Letter No. A2/20276/97

Sub: CMDA - Planning Permission - Construction
of Residential building at Plot No.58
S.No.197/28 Ashtalakshmi Nagar Varadharajapuram
Village - Development Charges and Other Charges
to be remitted - Regarding.

PLAN SHOWING THE PROPOSED ADDITIONS TO THE EXISTING BUILDING AT P.N. 58, S.N. 197/28, "ASHTALAKSHMI NAGAR", VARADRAJAPURAM VILLAGE, SRIPERUMBODUR - TALUK, CHENGALPATTU M.G.R. DIST. PADAPPAL PANCHAYAT UNION. FOR SCALE: 1"=8'0" (OR) 1:100.

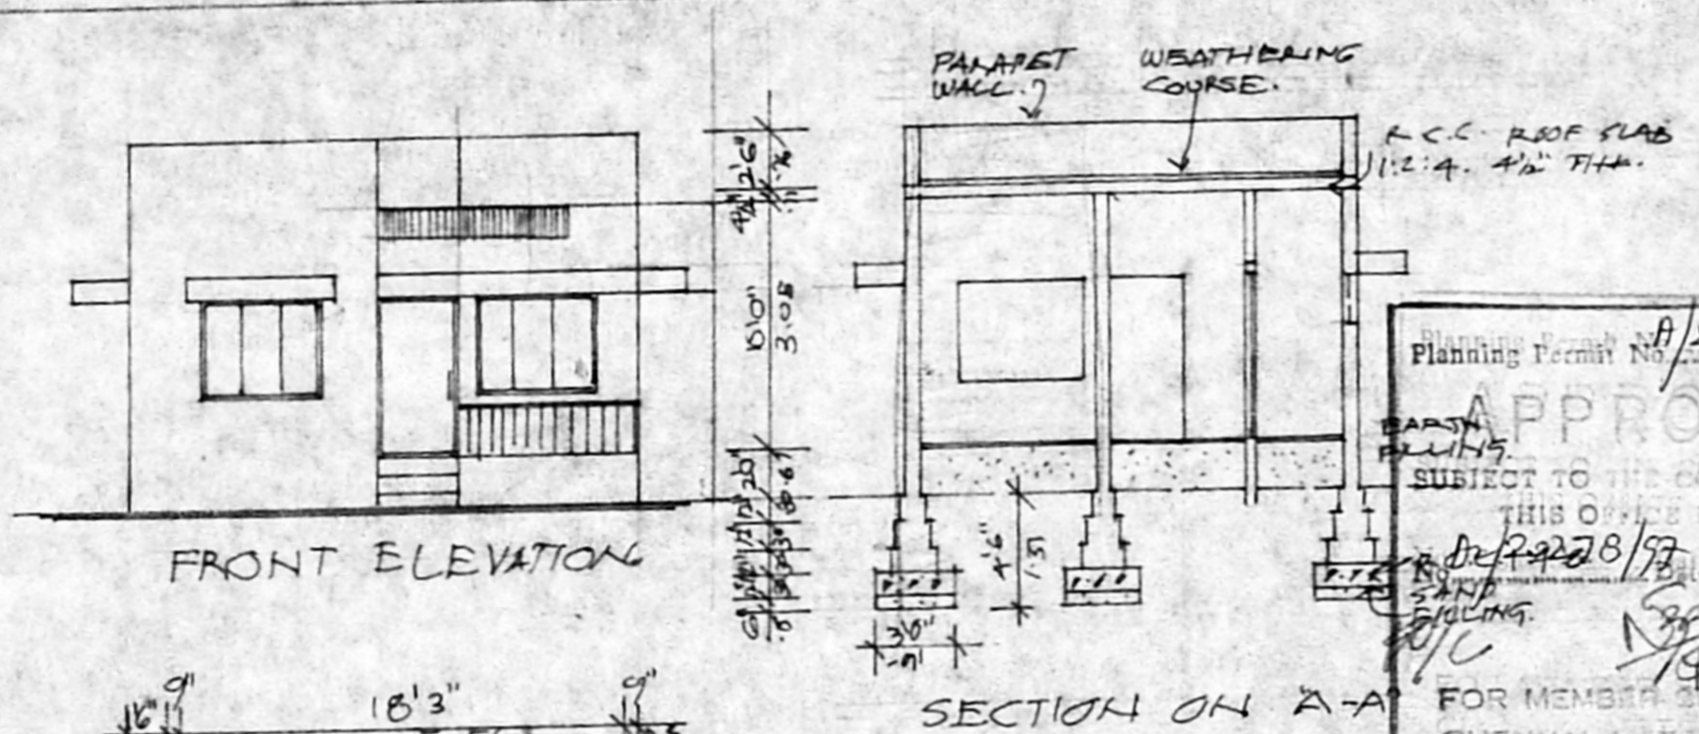
1. **Five Copies of plan showing the stair case as per the earlier approved plan.**
